**KIRKLEES METROPOLITAN COUNCIL
INVESTMENT & REGENERATION SERVICE**

DELEGATED DECISION TO DETERMINE PLANNING APPLICATIONS

| Reference No: | 2025/62/90414/E |
| Site Address: | Land adjacent, 38, Upper Road, Batley Carr, Dewsbury WF17 7LT |

PROPOSED HOUSE
ADJACENT
38 UPPER ROAD
BATLEY CARR

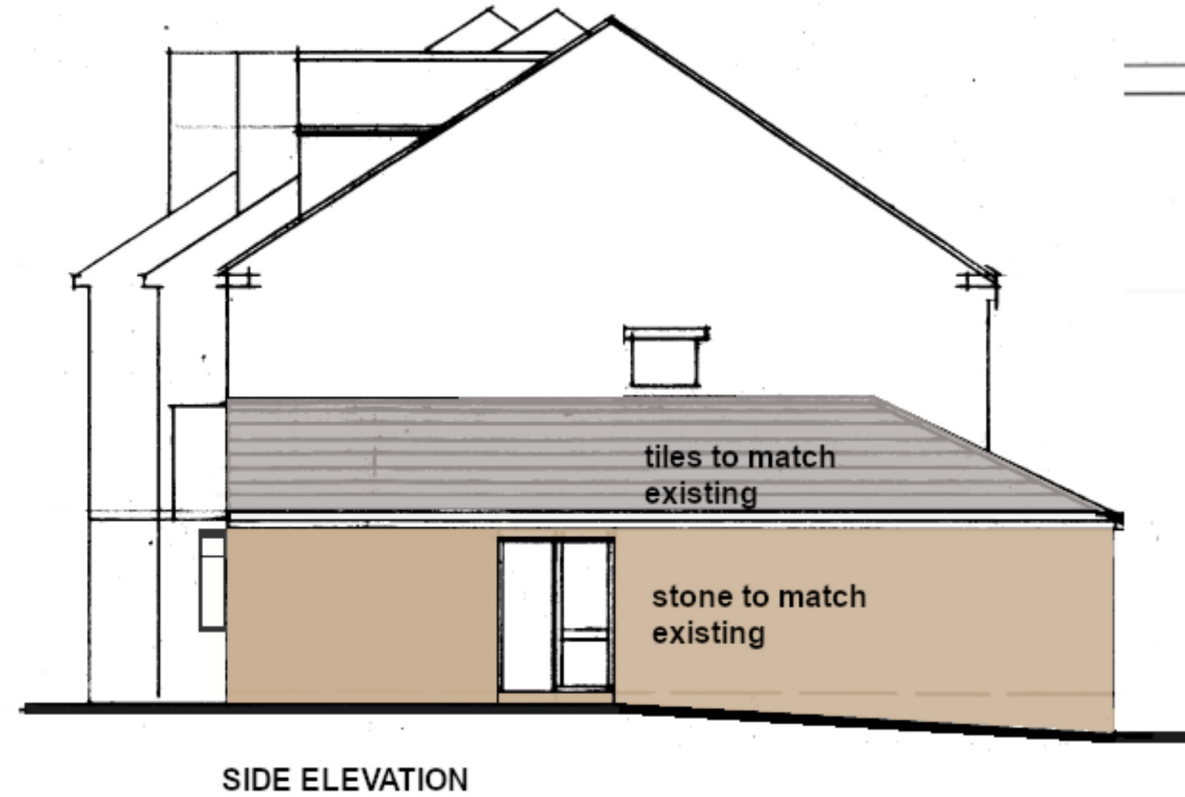
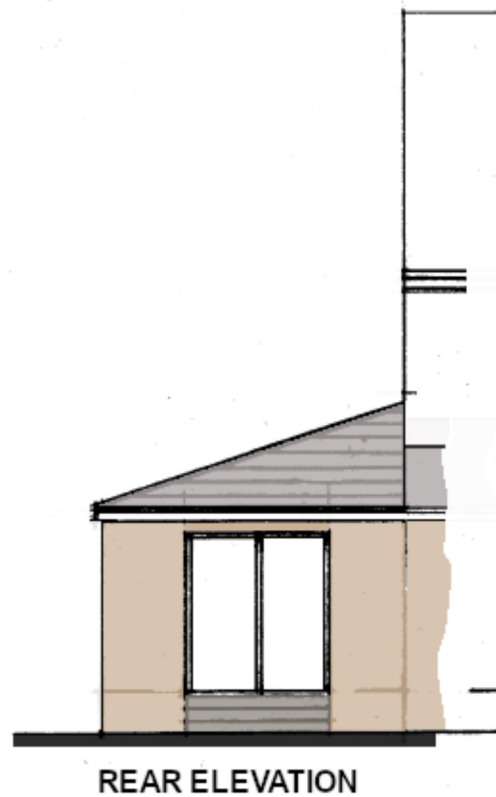
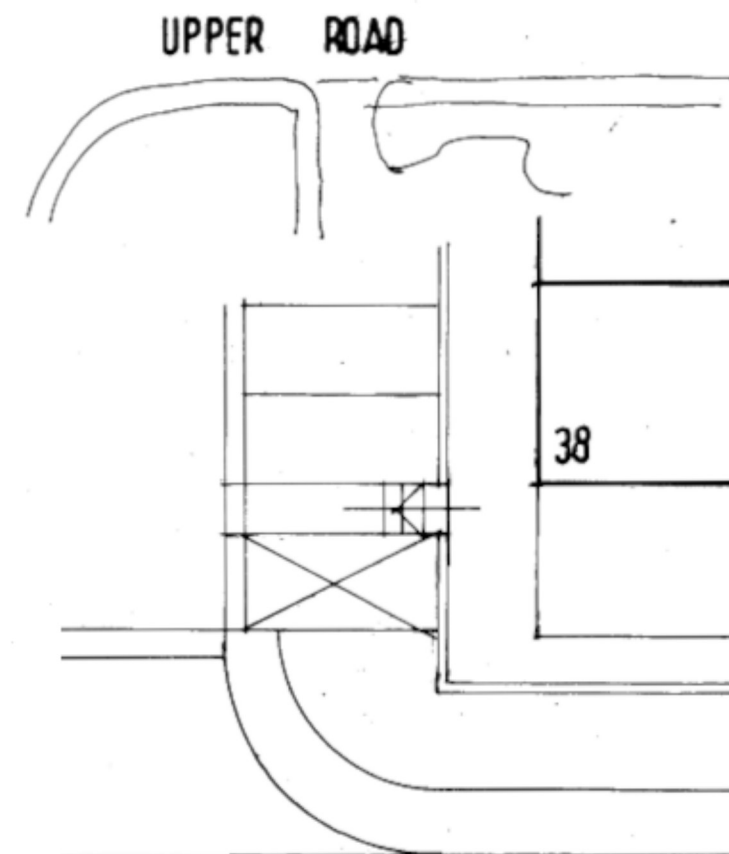
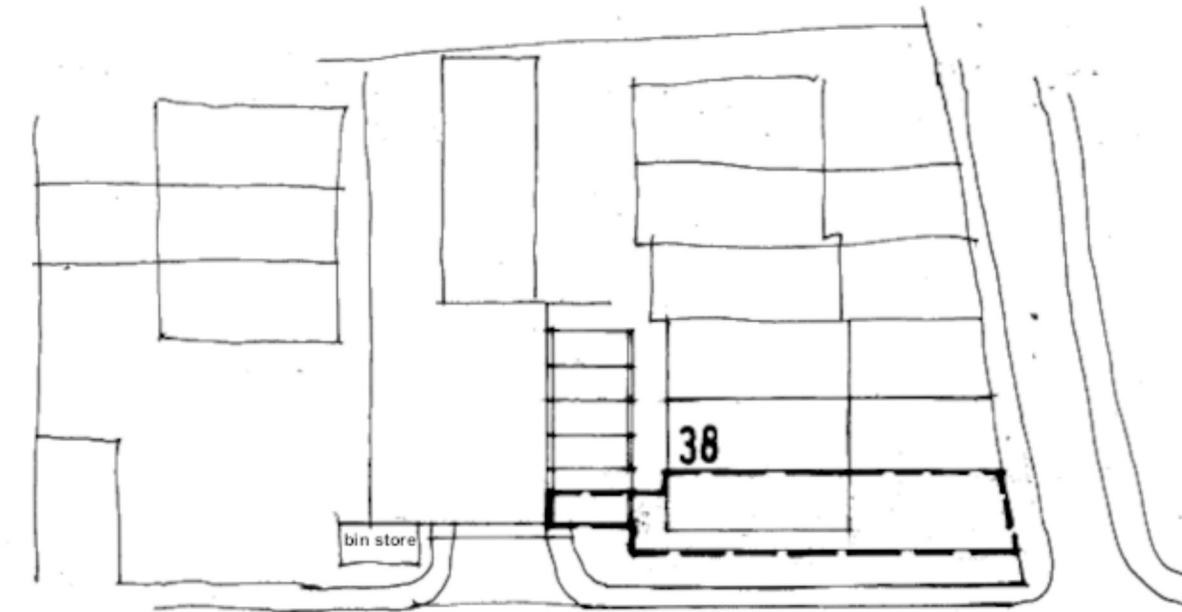
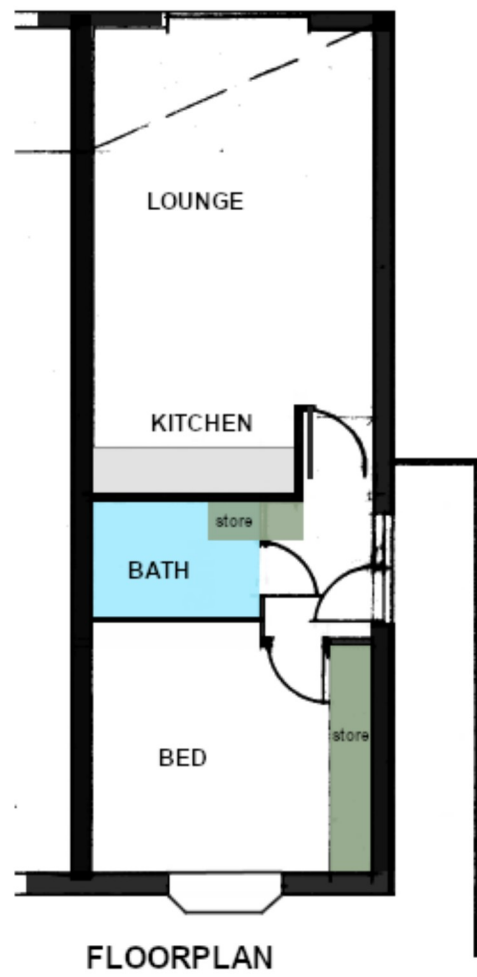
The applicant is seeking planning permission for the erection of a dwelling. The dwelling would be one storey in height, 4.00m(w) x 11.70m(l) with an eaves height of 2.30m and a ridgeline height of 4.00m. The building will be constructed with stone external walls and smooth grey roof tiles. It will have a rectangular footprint with a mono-pitched roof.

The application dwelling would be a 1-storey dwelling, which is placed in a position to the adjacent dwelling in terms of forward and rearward projection. There is a spatial pattern within the immediate section of Upper Road, with dwellings set away from the main street and spacious borders which provides an open character to the area. The proposed dwelling will be positioned on the end of the terrace row. Currently there is a 7.10m space to the side of the property, which will be reduced to 3.10m. The building has a low form therefore the perception of space is retained whilst preserving the visibility of Holy Trinity Church. For these reasons, the dwelling complies with Principle 2 of the Kirklees Housebuilders Design Guide SPD.

The openings and design features found within the dwelling are simplistic. A bay window will be installed within the front elevation. One set of patio windows will appear on the side and one on the rear. Given the simplicity of the design, the dwelling will appear pedestrian in nature and is acceptable in terms of Principle 14.

In terms of roofline, a mono-pitched roof has been chosen. It will appear as an extension of the building group and is acceptable in this instance.

Double bedrooms must be at least 11.5m² with the first been a width of 2.75m. The 'bedroom' indicated on the plans is 11.60m² and is 3.60m wide according with NDSS.

3. The dwelling shall be constructed reconstituted stone and concrete roof tiles as drawing details shown in grouped plans RevC received 30/05/2025. The materials shall in all respects match the appearance of the adjoining dwelling.

VISIBILITY SPLAY  
1.500

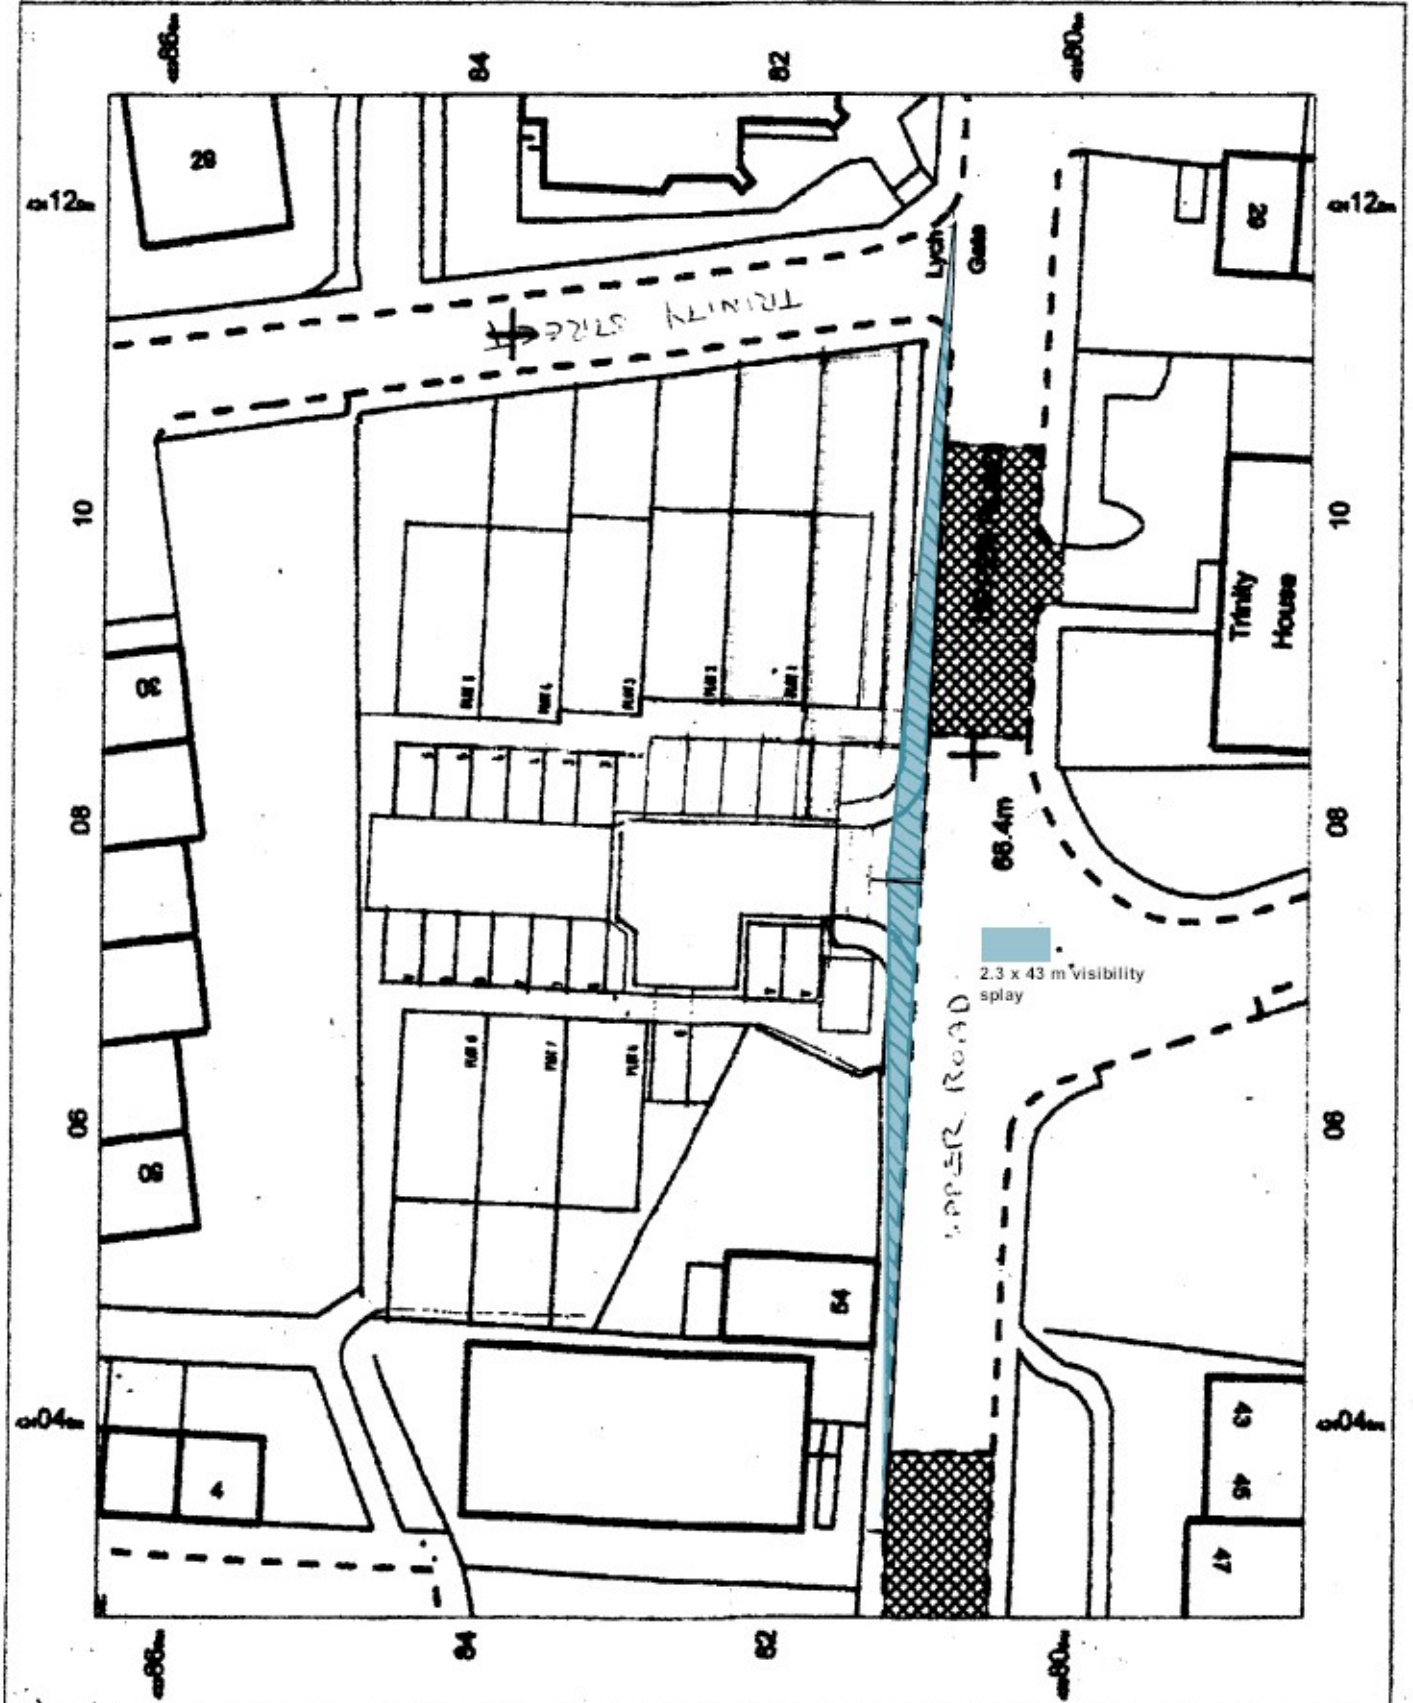
The applicant was asked to provide visibility sight lines for the access onto Upper Road, bin storage details and include architectural features on the building.

Visibility splays for access onto Upper Road have been provided indicating 2.3m x 43m sight lines would be retained.
